PLANNING STATEMENT

SITE: LAND ADJ LAKE BARN, MAYPOLE LANE, YAPTON, WEST SUSSEX, BN18 0DR

PROJECT: ERECTION OF DETACHED SINGLE STOREY DWELLING HOUSE WITH VEHICULAR ACCESS FROM MAYPOLE LANE

3.1 DISCHARGE OF CONDITIONS 04 & 05

Scale:	Drawn By:	Date:
1:50 @ A2 BC		20/12/'19
Project:	Drawing No.	Revision
MAY01	110/ 09	-

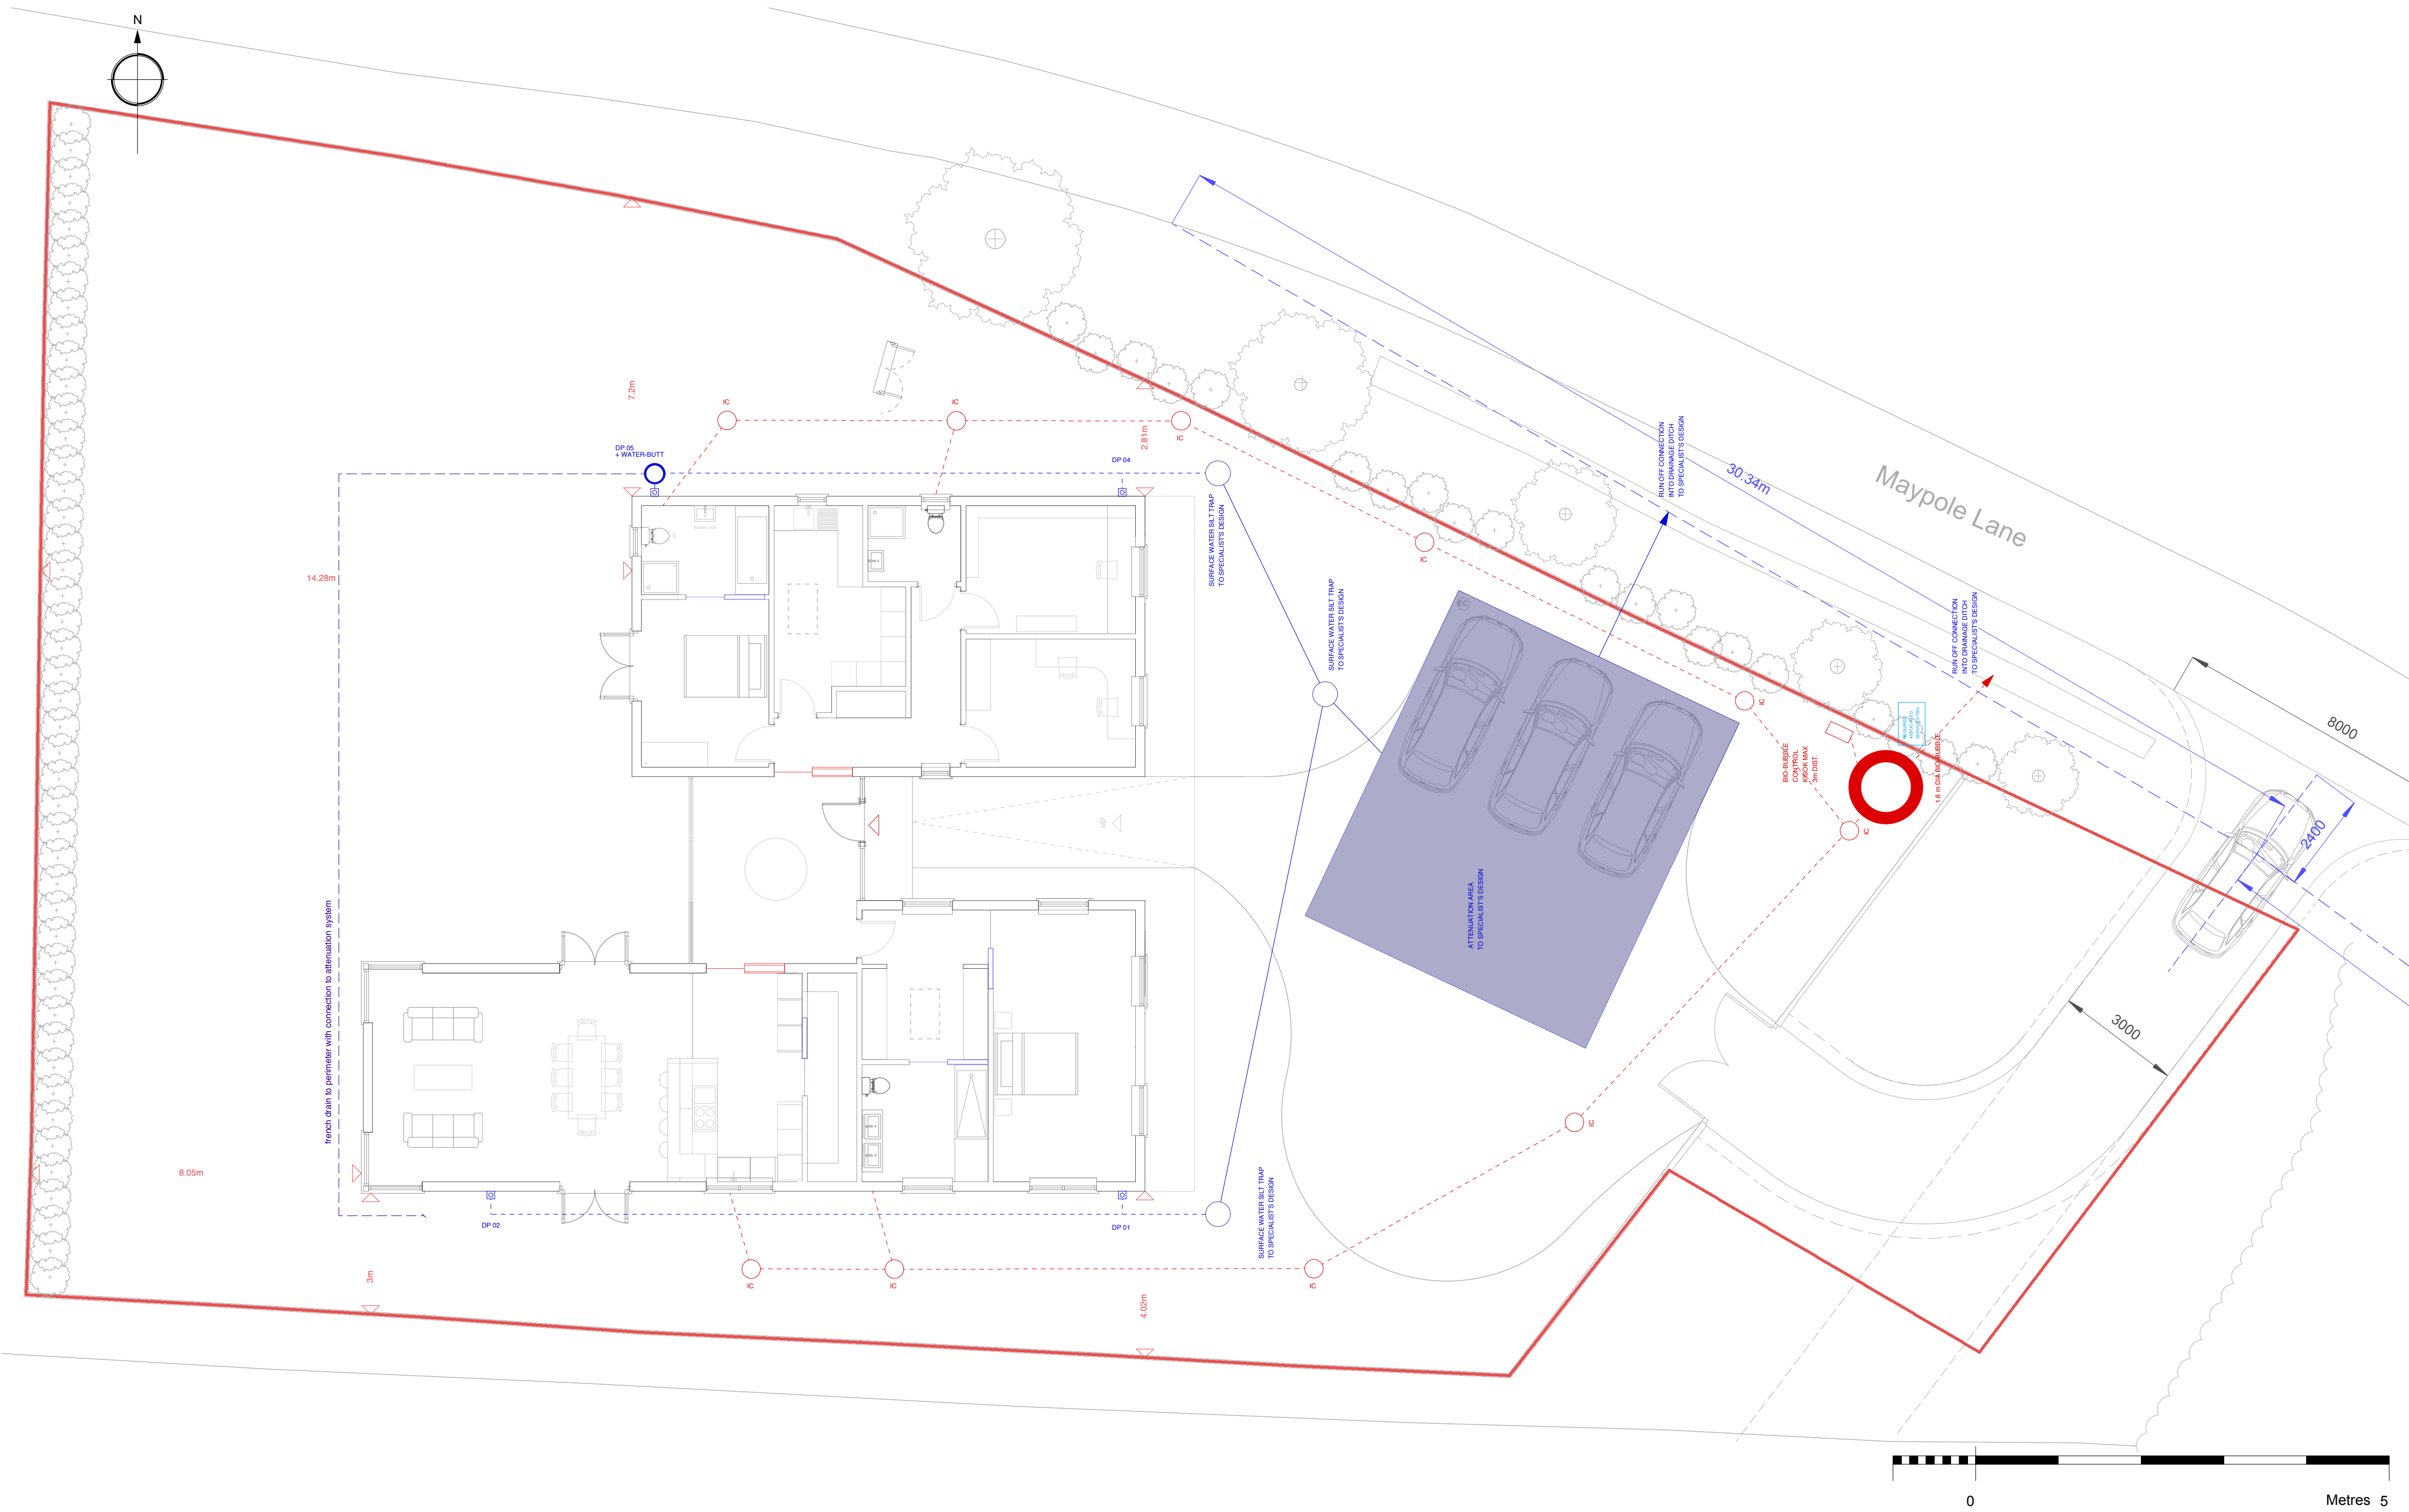
1. Ordinary watercourse land drainage consent will be required for any proposals to discharge to ordinary watercourse.
2. Outflow should be restricted to greenfield O/R or 2l/s, whichever is the greater. Any proposals to discharge at rates lower than this are unlikely to be acceptable due to the risk of blockage.
3. Infiltration rates were found to be good in some locations. Can a plan be provided showing where soakaways could be located, i.e. 5m buffer from building.
4. Full calculations, layouts and detail drawings will need to be provided in accordance with our checklist that can be found here <https://www.arun.gov.uk/downloads/16131>

- (a) *The outfall rates have been increased to a min 1.9l/s using a 60mm orifice;*
- (b) *Annotated the layout plan on page 25 of the report (reference land beyond 5m);*
- (c) *Inverts levels have been added to the layout plan on page 25. Sedum, water butt flow diverter, headwall, Polypipe Permavoid crate and orifice chamber details were all already provided. Calculations now updated to the 60mm orifice and max 250mm design head within 300mm deep cells.*

110/09 Rev A dated 07 January 2020
